**Recommendation Report for Lawful Development Certificate for a Proposed Use or Development**

**REF NO:** LU/48/13/CLP

**LOCATION:** 35 Grove Crescent  
Littlehampton

**PROPOSAL:** Application for certificate of lawfulness for proposed removal of hipped roof and replacement with gable end and extension of dormer at first floor level

PROPOSED ELEVATIONS

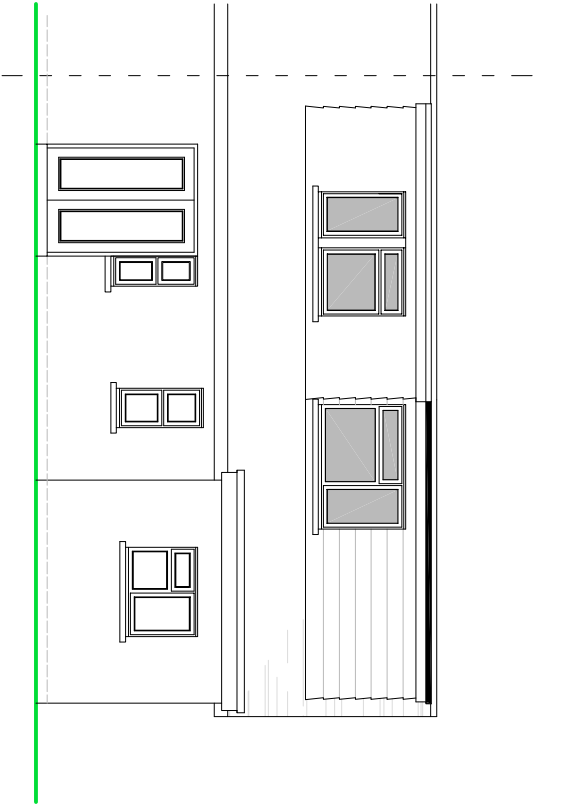
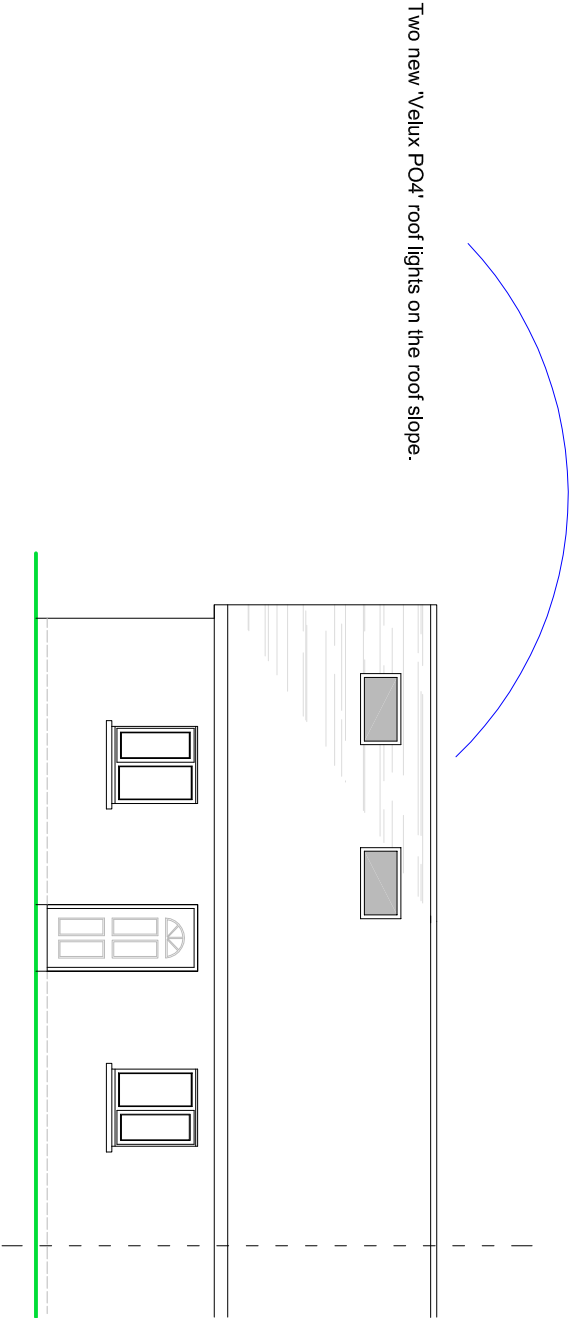
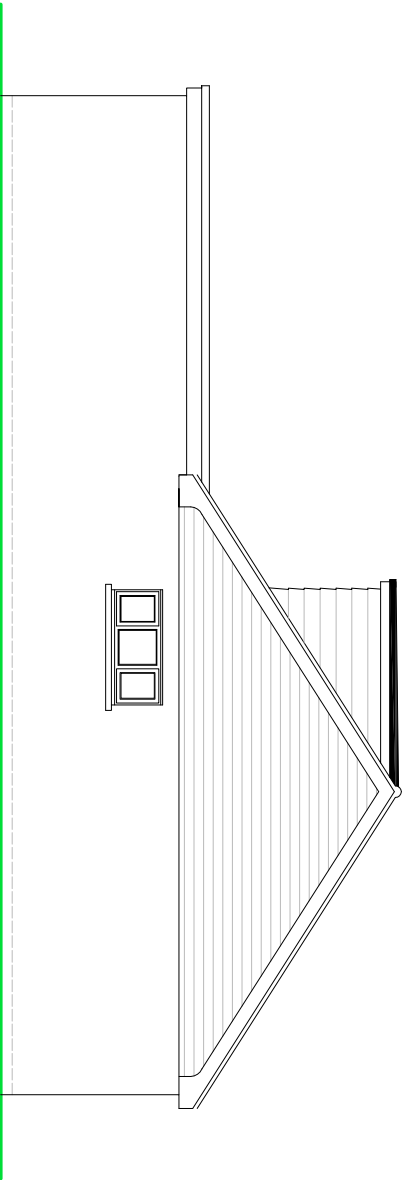
The proposed roof extensions and alterations would not exceed the highest part of the roof and would not extend beyond the plane of the existing roofspace forming the principal elevation of the dwellinghouse. The proposal therefore complies with Class B.1 a) and b).

The combined cubic volume of the proposed enlarged dormer and hip to gable roof extension is 32.8 cubic metres and does not exceed 40 cubic metres and therefore complies with Class B.1 c).

Class B.2 states that development is permitted by Class B subject to conditions to ensure that external materials are of a similar appearance to those of the main dwellinghouse; the edge of the enlargement closest to the eaves of the original roofline shall be not less than 20 centimetres from the eaves of the original roof; and any window opening on a side wall or roofslope shall be obscure glazed and non-opening above 1.7 metres from finished floor level. The proposal complies with the above conditions as per the submitted plans.

The proposed roof light will not extend above the existing roof plane by more than 150mm. The proposal complies with Class C.1 a).

The proposed roof light will not be higher than the highest part of the original roof. The proposal complies with Class C.1 b).
